Phone: 0300 123 6780
Email: developeras@lancashire.gov.uk
Your ref: 3/2026/0006
Our ref: 3/2026/0006/HDC/KW
Date: 23 January 2026

Location: Monks Barton Longsight Road Langho Lancashire BB6 8AD
Proposal: Proposed single storey double garage to replace adjoining dilapidated workshop, coal store and timber garage. Conversion of existing garage into bedroom/ensuite. Replacement of septic tank with sewage treatment plant.
Grid Ref: 370150 434646

7276 - P02C

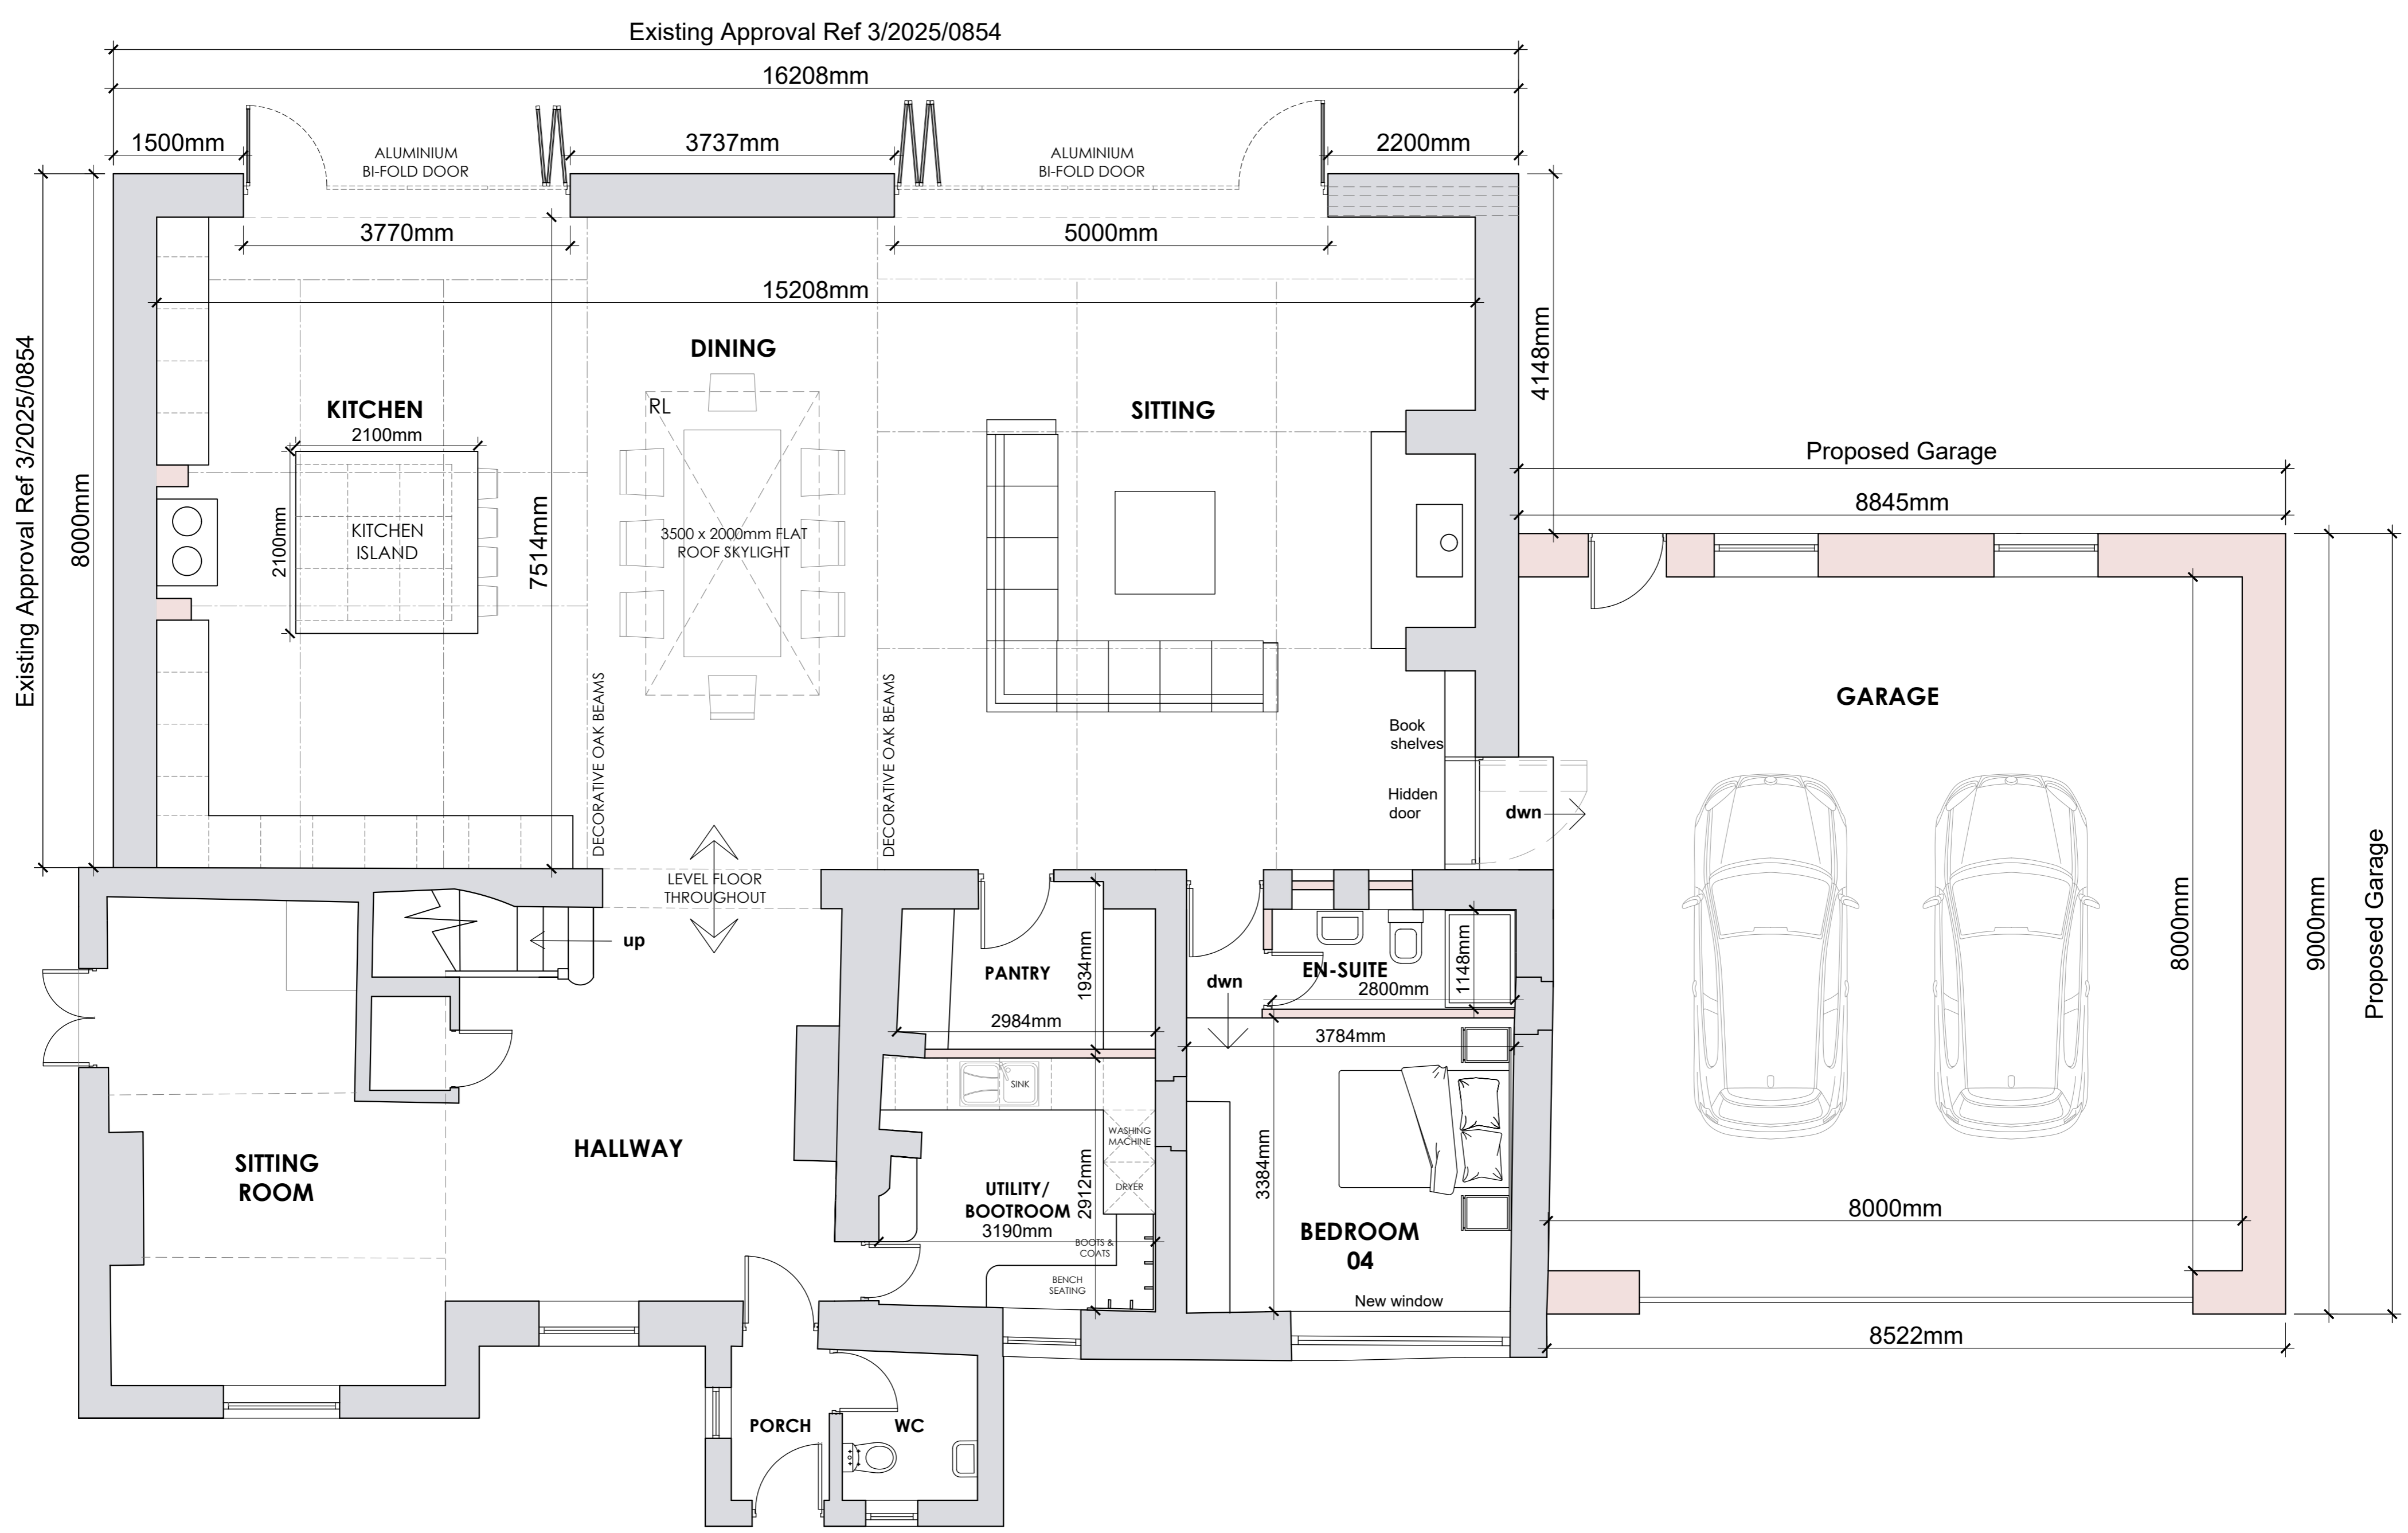
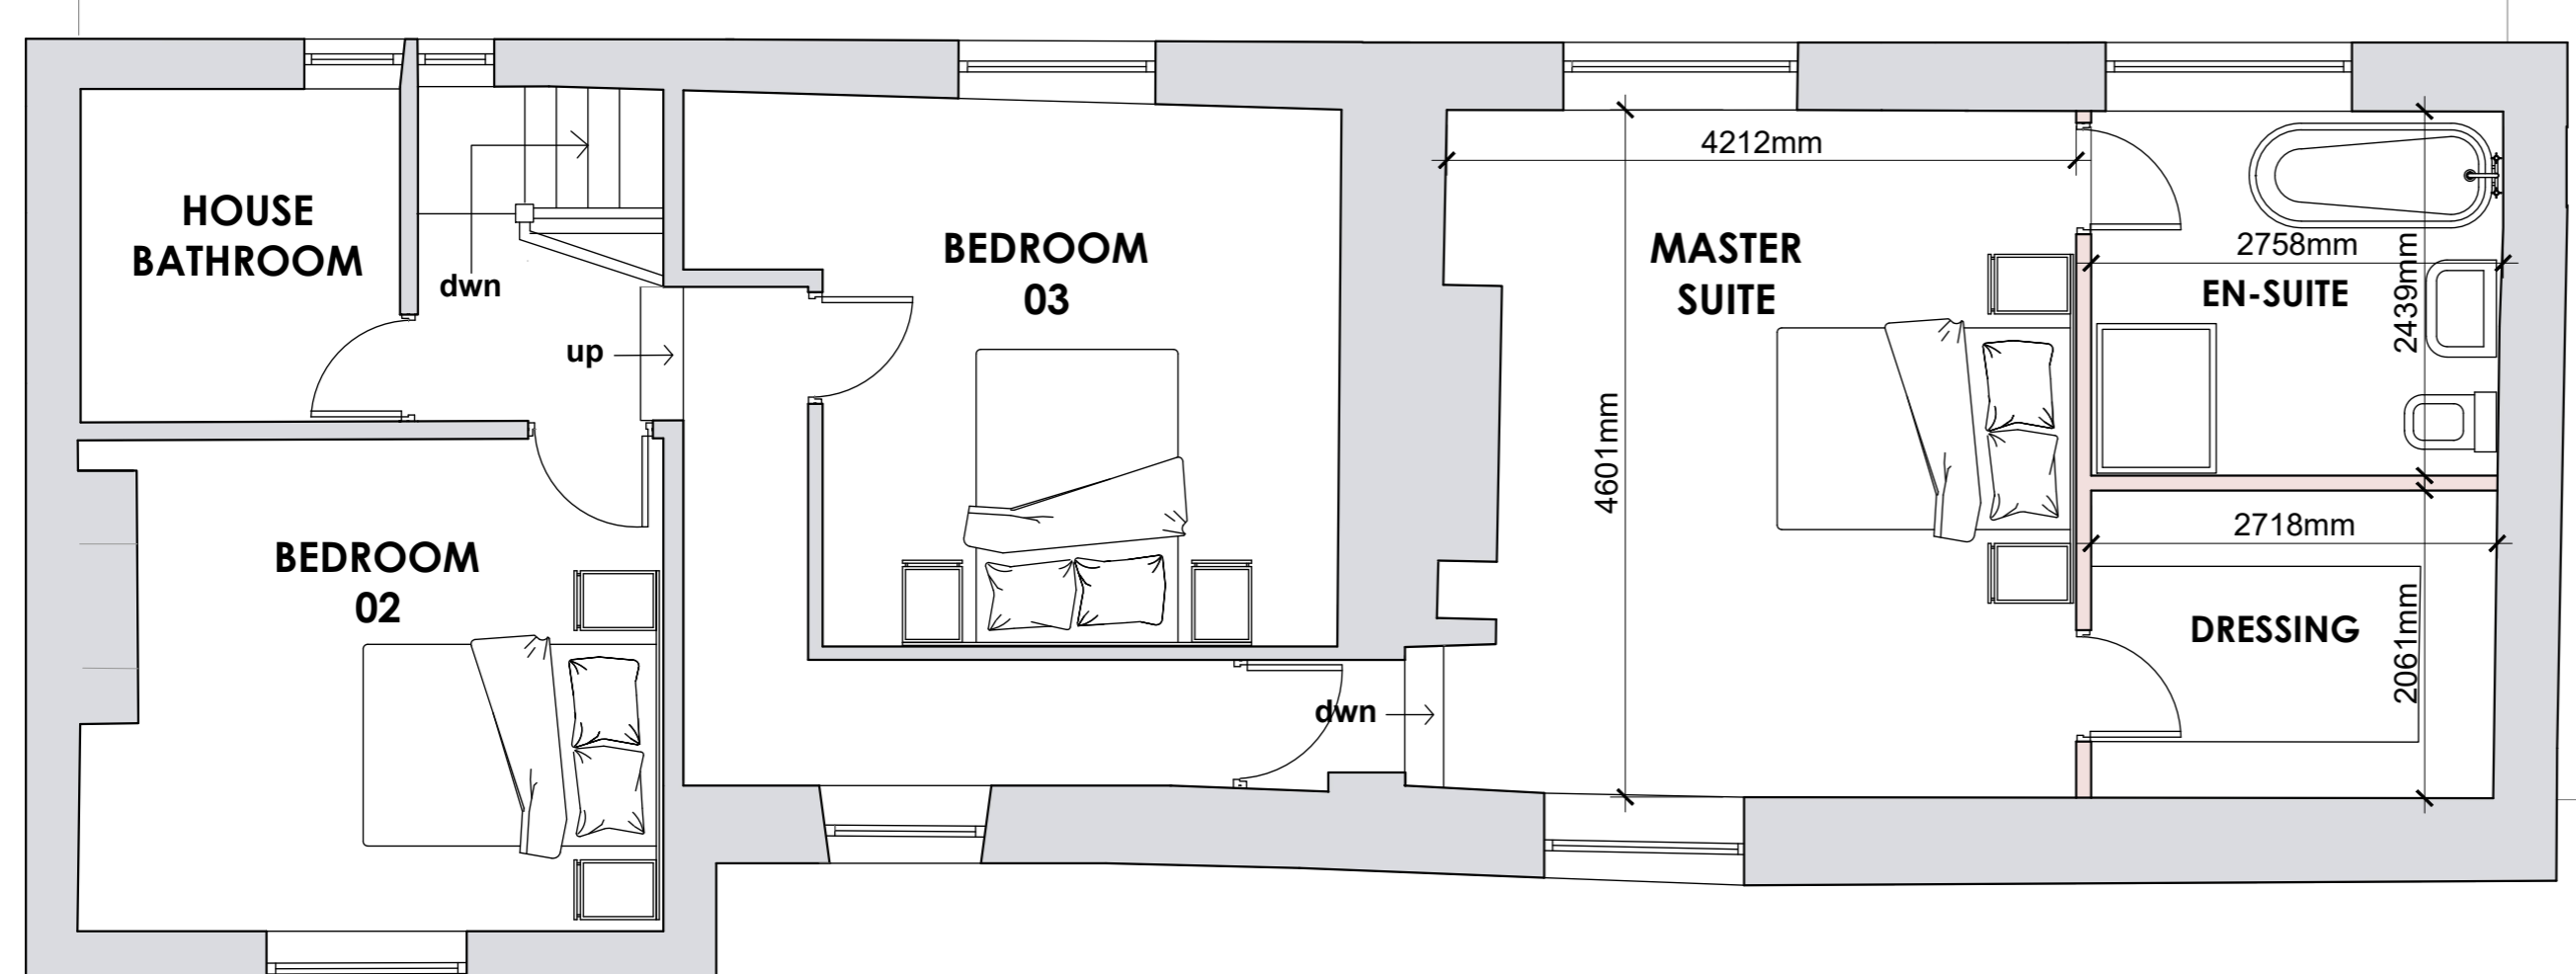
The recommended minimum internal dimensions for double garages are 6m in length and 6m in width. As such, the proposed garage is an acceptable size to provide parking provisions.

7276 - P03

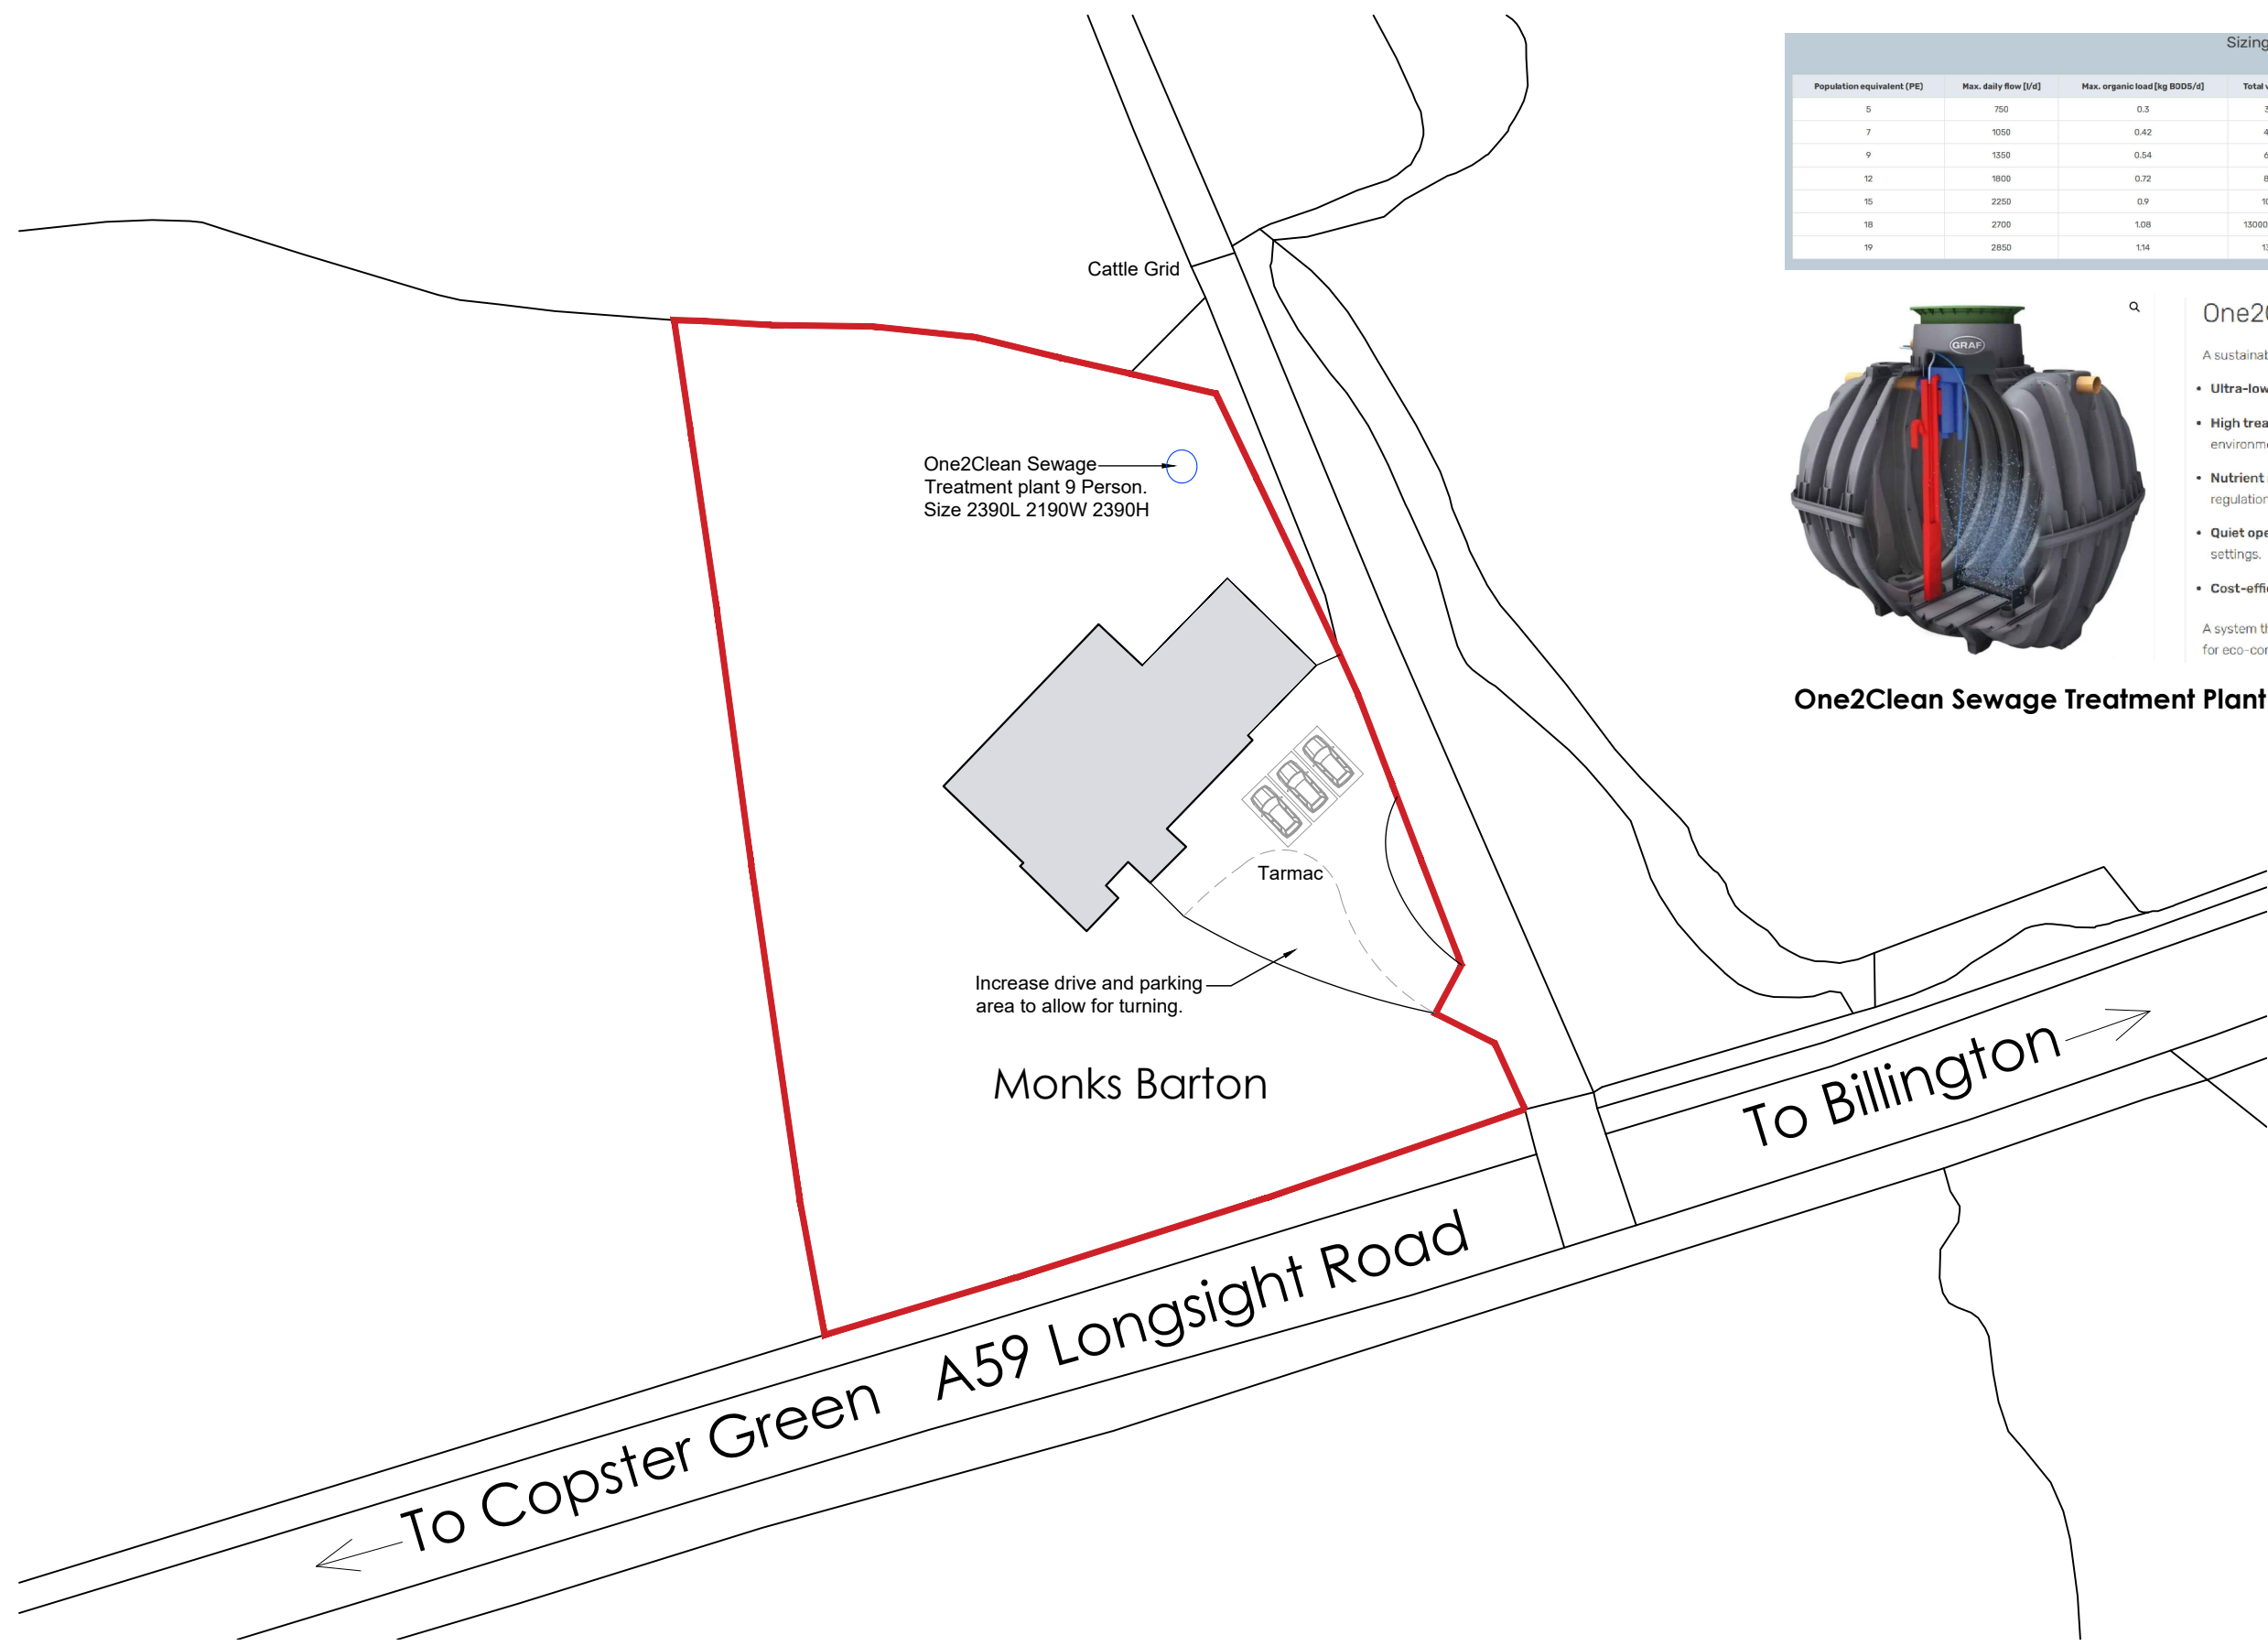
The LHA have reviewed drawing number 7276 – P03 titled Proposed Site Plan. Parking is available for at least 3 vehicles. The proposal includes an extension to the parking area which will facilitate turning in order to enter and leave in forward gear. As such, the dwelling complies with the LHAs parking standards as defined in the Joint Lancashire Structure Plan.
